**Cawston Parish Council, Norfolk Boreas Offshore Wind Farm Inquiry, Deadline 13 submission.**

Cawston Parish Council wishes to make the following submission at Deadline 13. This includes points made in oral contributions at the Open Floor Hearings on 2<sup>nd</sup> (OFH 2) and 16<sup>th</sup> July (OFH 3c) and a report on our meeting with Vattenfall on 21<sup>st</sup> July.

Figure 2.1 Accident Records (source: Crashmap.co.uk)

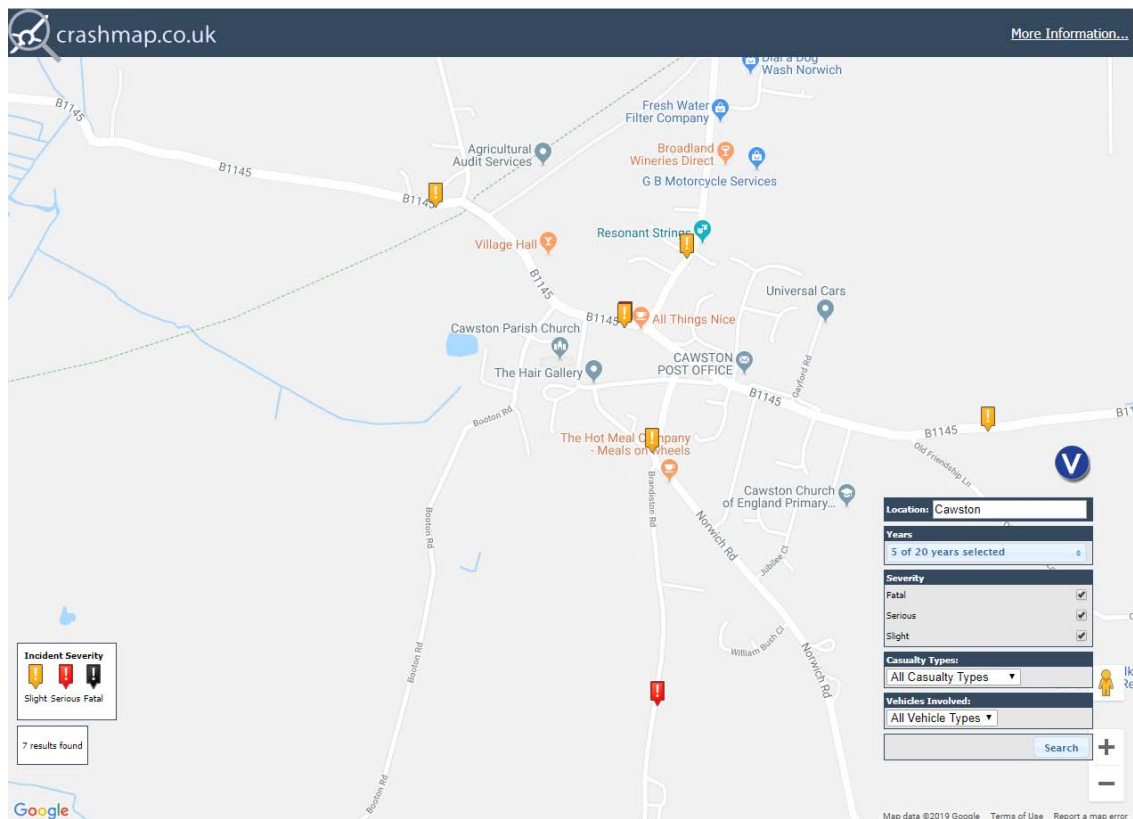
CPC does not have access to the accident data the applicant used in their assessment of the accident risk in Cawston High Street.

Appendix 1 shows an output of the CrashMap accident data available for Cawston, showing the pattern of accidents under existing traffic conditions. Commenting on the Crashmap accident data which is available to Cawston Parish Council, the applicant suggests that, in the village centre, two accidents don't make a cluster thus providing insufficient data to apply their statistical model.

Not using a statistical model because you have insufficient data to use that model means that model's output fails to predict any outcome for the highway intervention scheme, safe or otherwise. It seems that, for the proposed Cawston HIS, the applicant's predictions of a safe scheme are based on not having sufficient data gained under current traffic conditions to apply to a statistical model. This lack of evidence appears to be no impediment to making predictions of accident risk under conditions of much heavier traffic flows through the village.

CAWSTON HIGH STREET - INTERVENTION SCHEME  
Scale 1:500

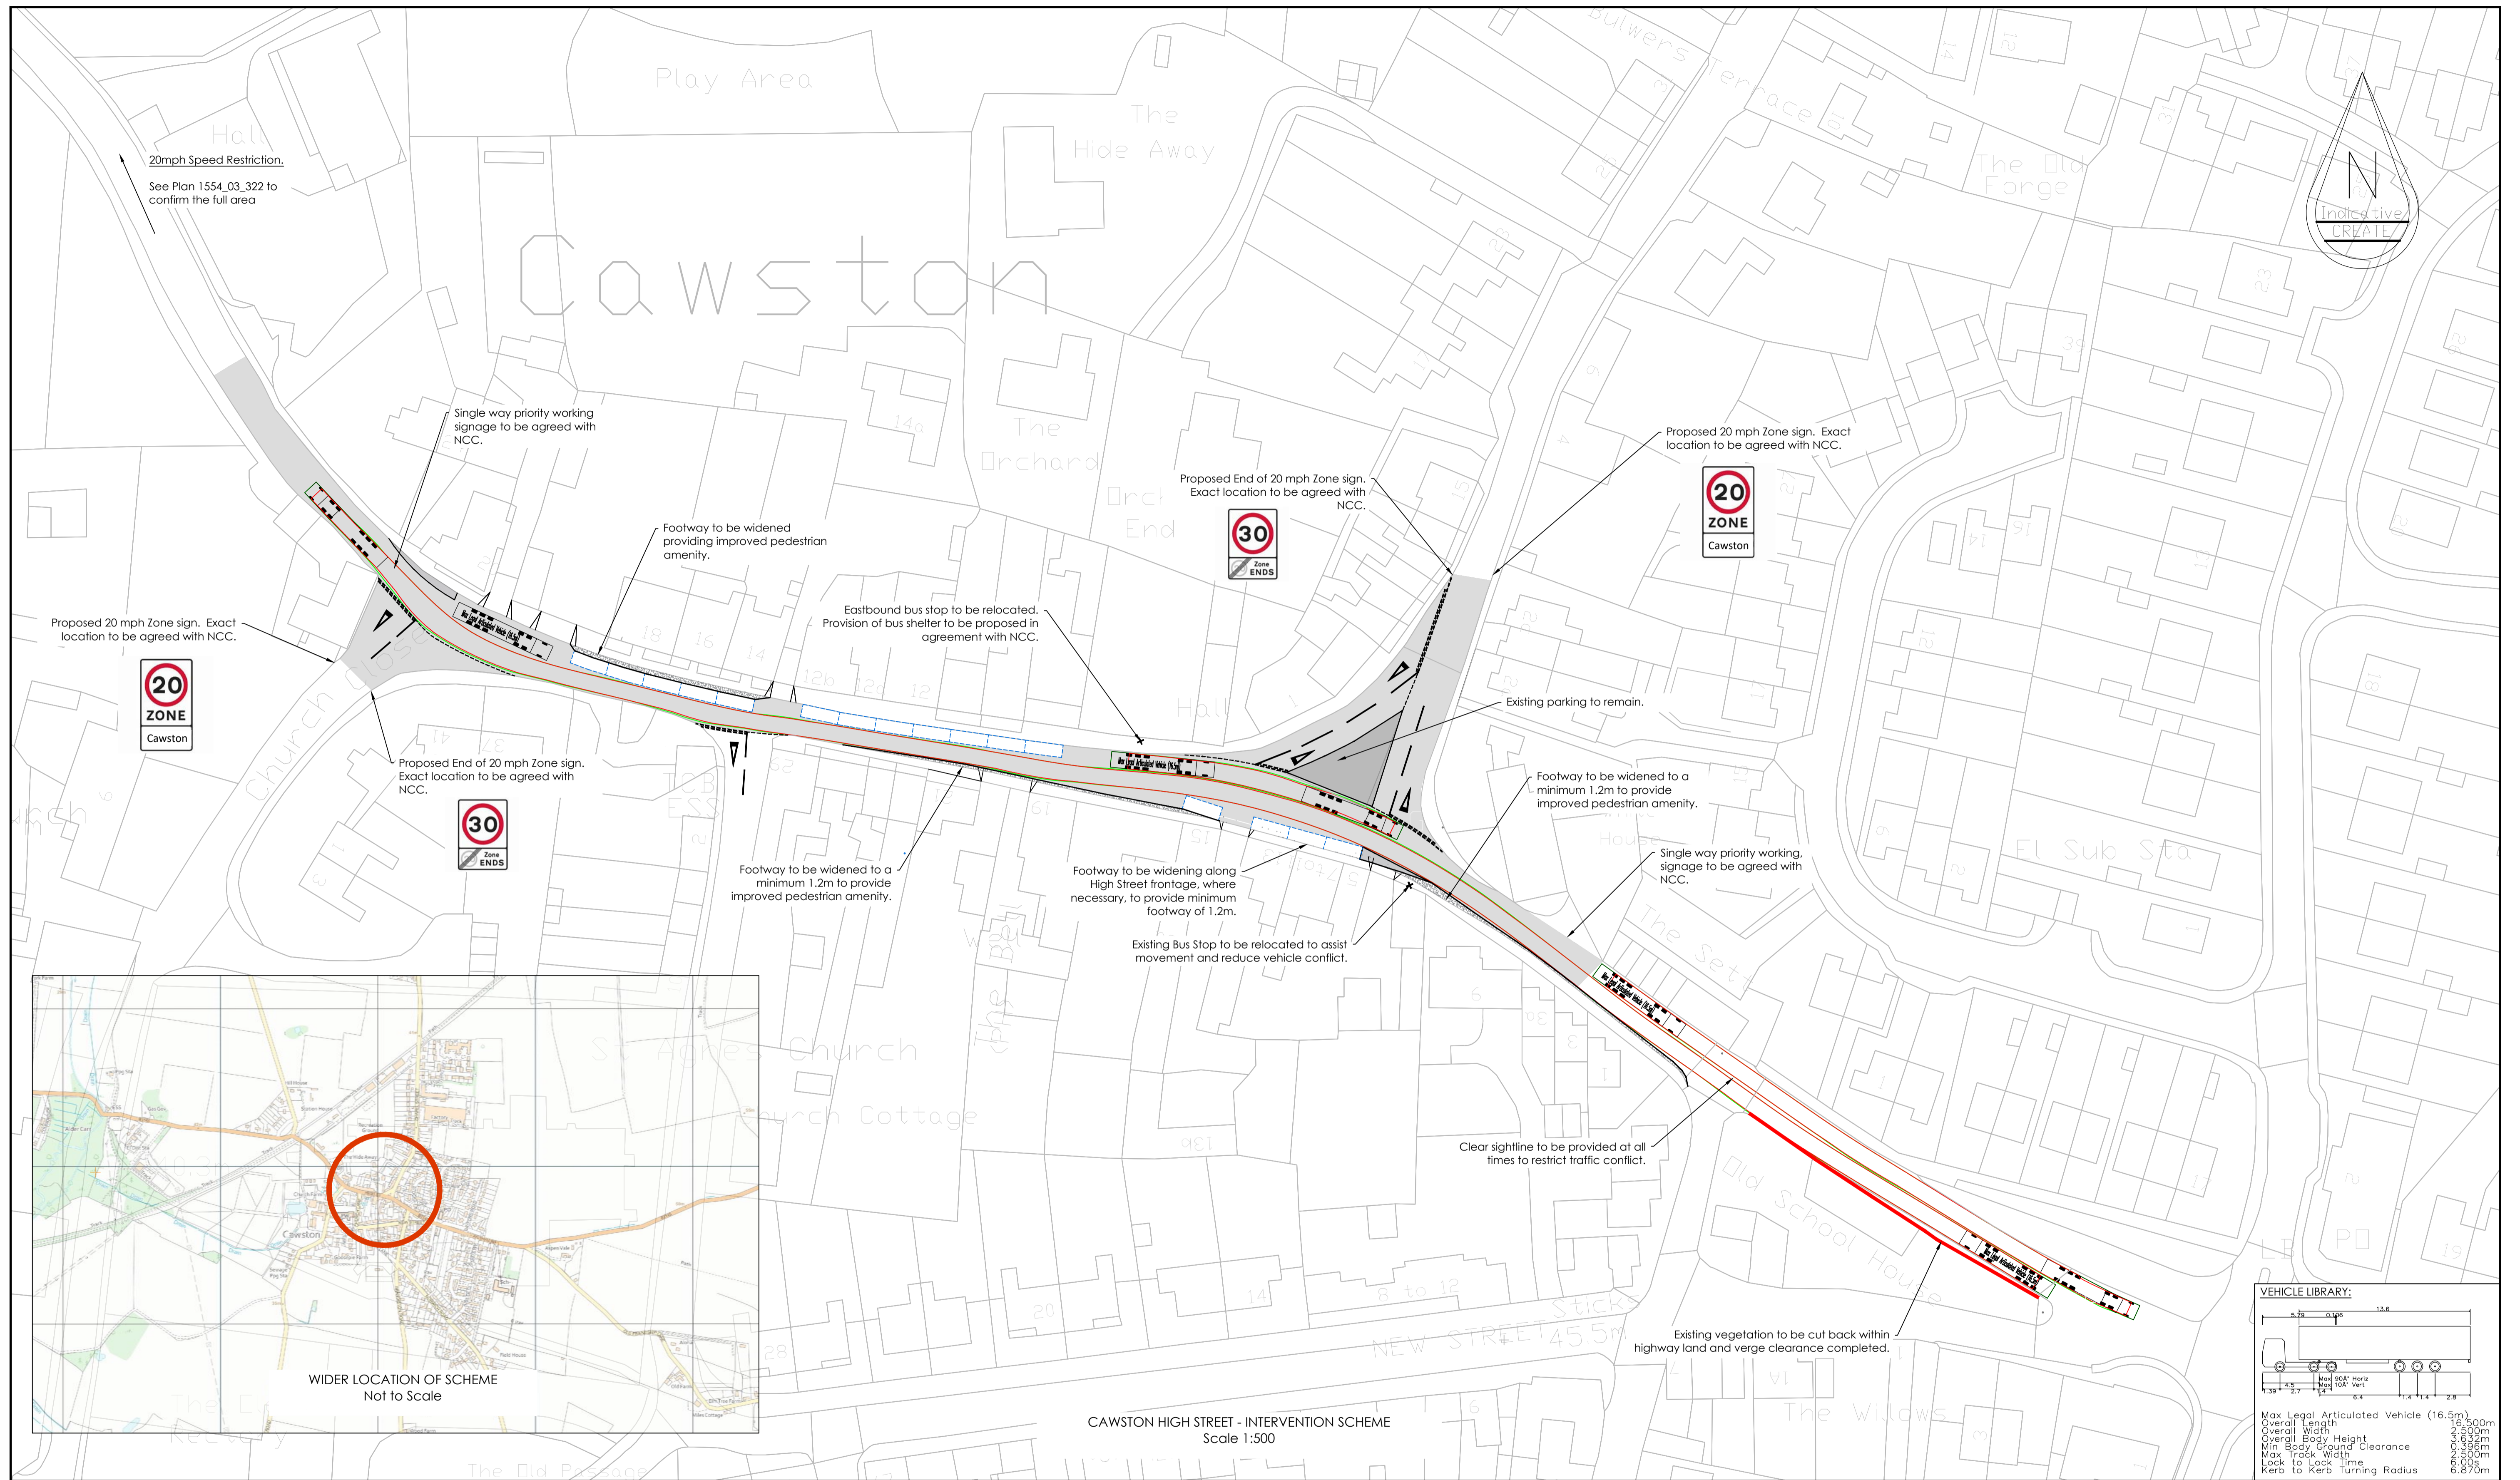
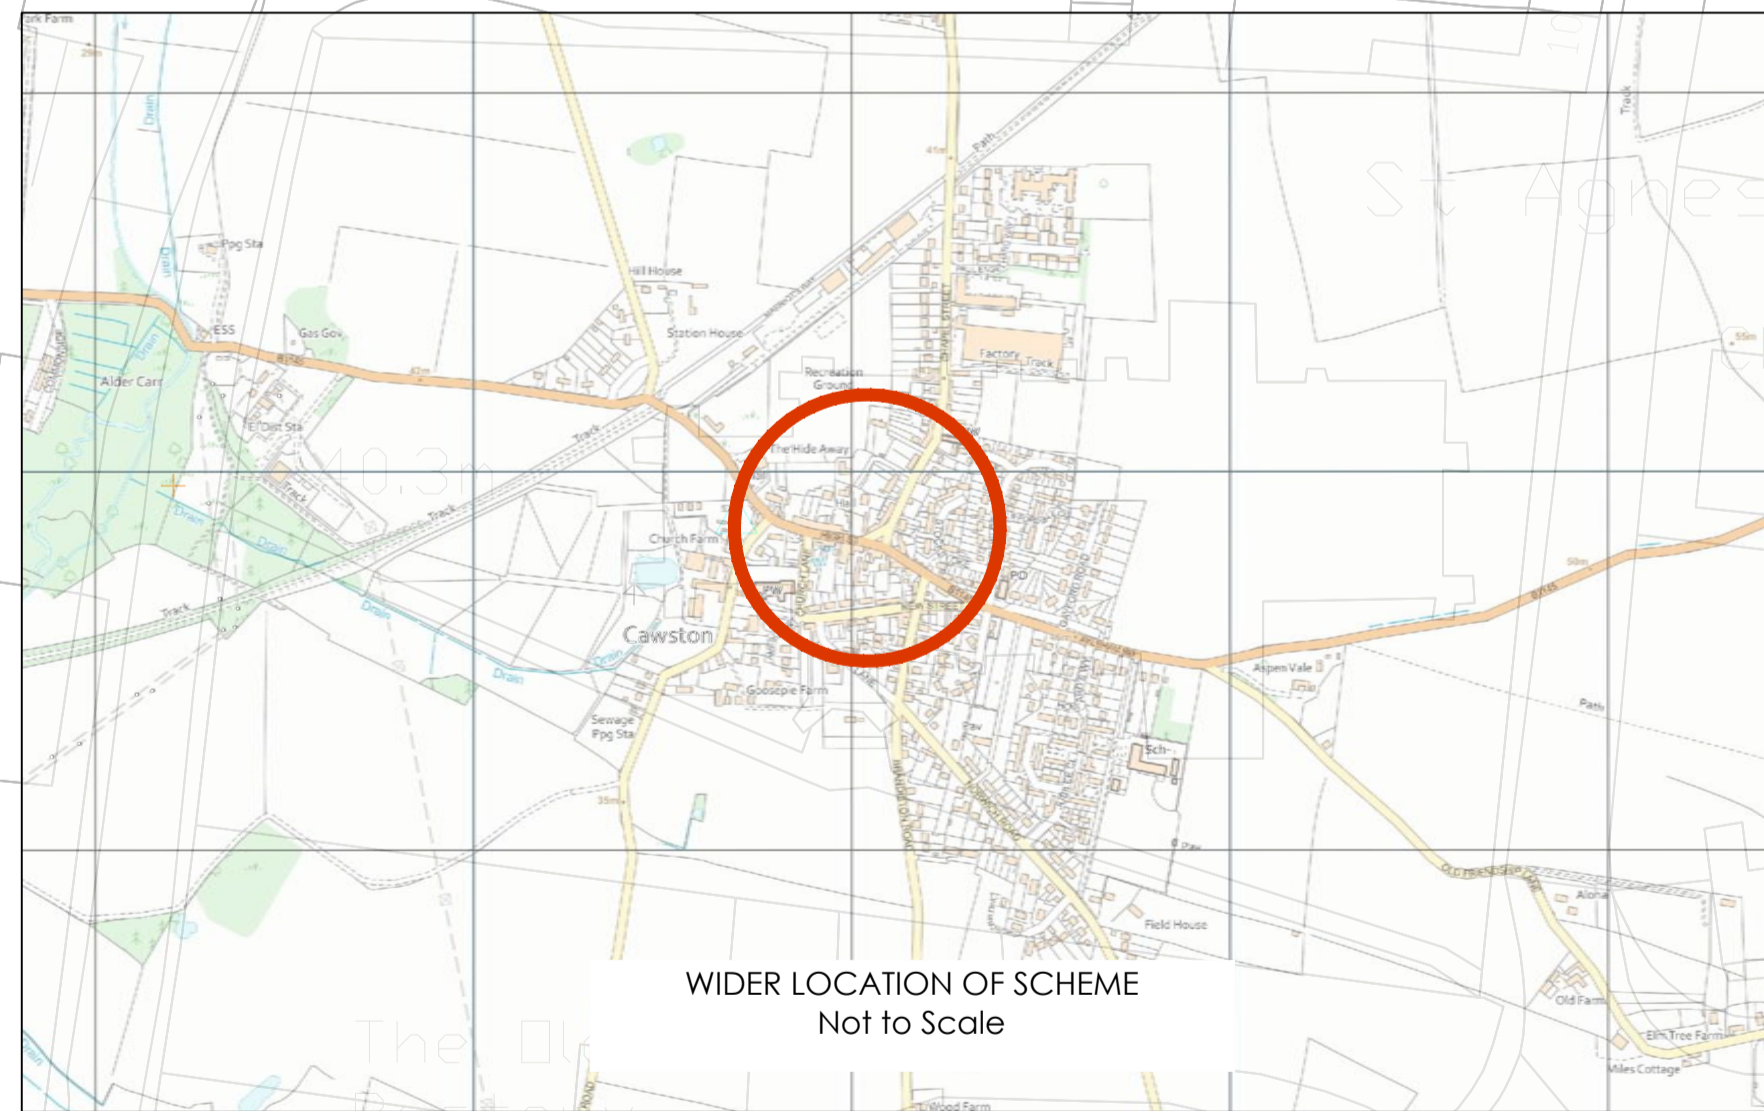
The applicant’s new Highway Intervention Scheme fails in its aim to provide adequate road space for HGVs to traverse the High Street without the requirement to mount or project over the pavement; The potential for two-way movement for construction traffic through Cawston is claimed to be demonstrated by the applicant’s swept path analysis modelling. This modelling is represented in maps which purport to show where large tipper trucks or articulated vehicles may pass in the central part of Cawston.

Even in the wider areas of the High Street the gap between the tracks plotted are hardly distinguishable. The overall widths of vehicles used in the swept path analysis are 2.495 m for the Large Tipper and 2.55metres for the articulated lorry. Track width of the lorries are stated as 2.471 metres and 2.5metres.

The swept path analysis appears to have been conducted at the track width without mirrors. The space allowed between passing vehicles is difficult to determine viewed at any scale. The applicant seems to be content that all drivers in any vehicle in Cawston will possess the above average driving skill they attribute to their drivers.

The Highway Intervention Scheme seems to rely on HGVs finding their way to the two designed passing spaces as HGV to HGV passing is not possible in other areas of the High Street.

The HIS designates a passing space at the junction of Booton Lane, labelled on the swept path plan as *No conflict when third large tipper in queue is stationary*. This boast relies on no other vehicle finding its way between the three tippers, an unlikely scenario since other vehicles do use the B1145 and the Traffic Management Plan suggests that HGVs will be released at spacing to avoid platooning.

In the event that one tipper travelling from the west is followed by say a couple of cars and a van and they can find their way across Salle Beck Bridge, over the old railway bridge avoiding pedestrians in the road and eventually arrive at the HGV passing space at the junction with Booton Lane then a second tipper, and any other following traffic, would find itself waiting, not in the designated passing place, but in what is marked on the swept path analysis plan as a potential *two way Large Tipper HGV Conflict Zone*, effectively barring progress of all but the narrowest oncoming vehicles travelling from the east. If the second tipper has collected traffic behind, likely in a 20mph zone, there would be no opportunity to enable approaching traffic to pass. A third tipper following may well be stuck in a stream of traffic on the old railway bridge, also obstructing oncoming traffic.

The applicant proposes reducing parking spaces by removing parking on some parts of the High Street and by taking a metre of the triangle of parking opposite the delicatessen at the end of Chapel Street. This, we are told will have no effect on the number of vehicles which can park there. Presumably the applicant expects vehicles to somehow park closer together, and drivers to enter and exit through the boot as there won't be room to open the doors.
